Our Ref: LU/65/19/CLP
Your Ref:

Application for Lawful Development Certificate for a Proposed Use or Development

Development Lawful development certificate for a proposed replacement kitchen & bathroom single storey extension.
Location 24 Sussex Street Littlehampton

Proposed Site Plan at 1:500 scale

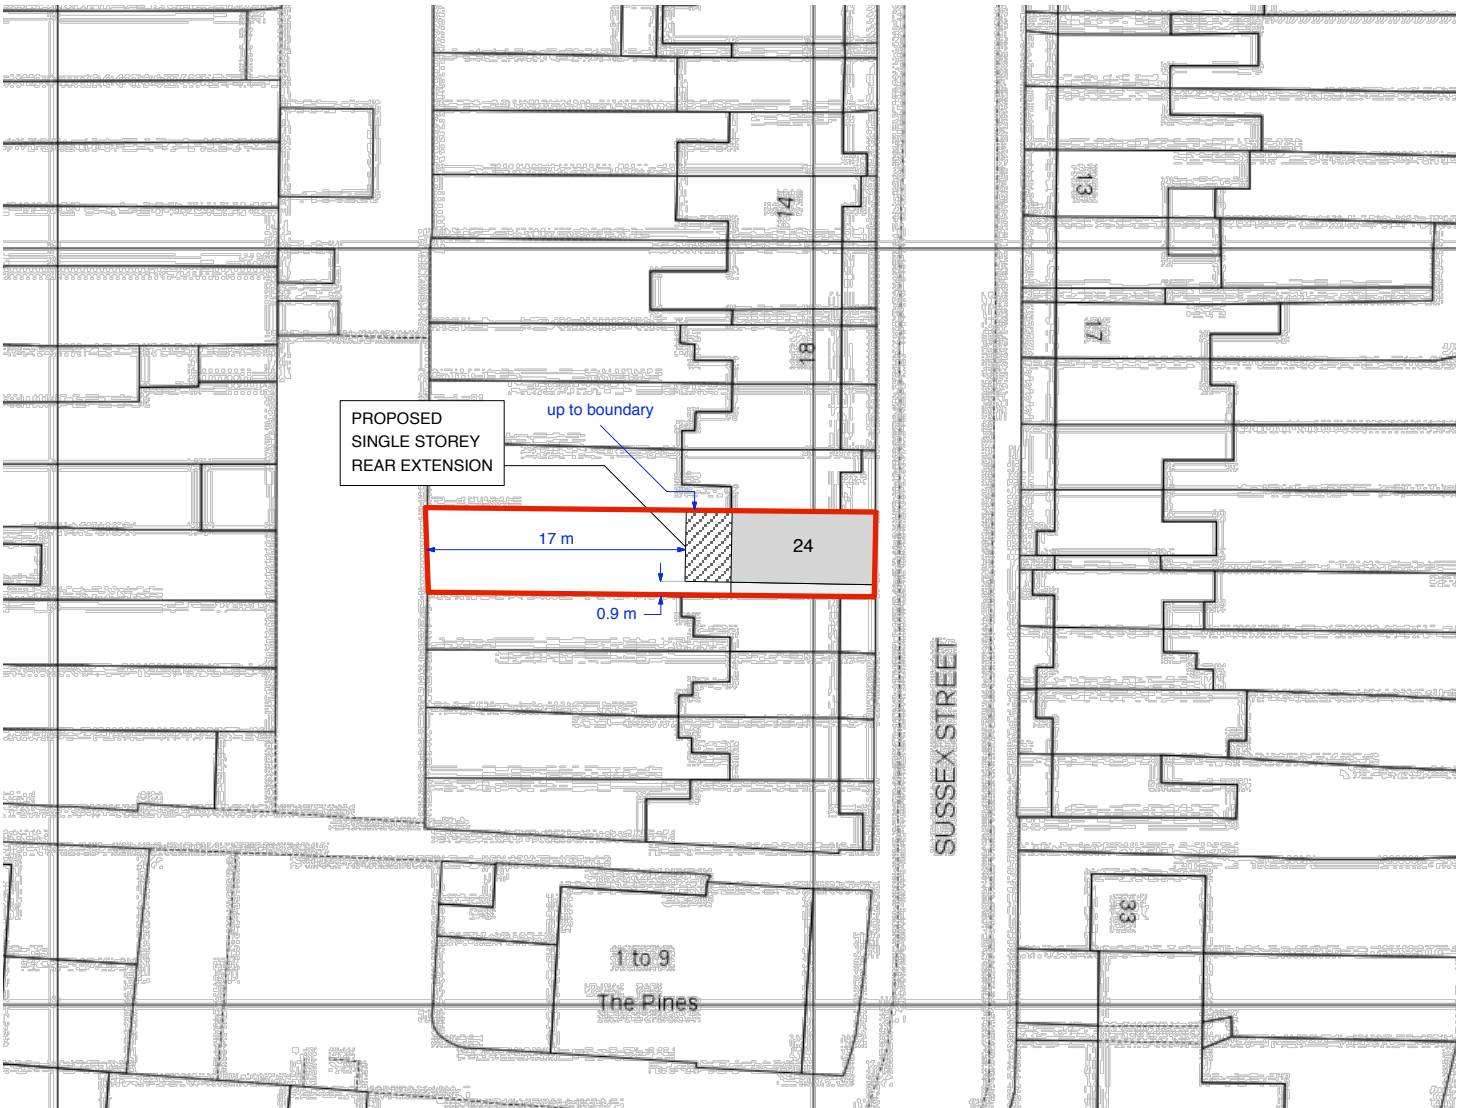
Please provide dimensions on Block Plan from the proposed extension to boundaries.
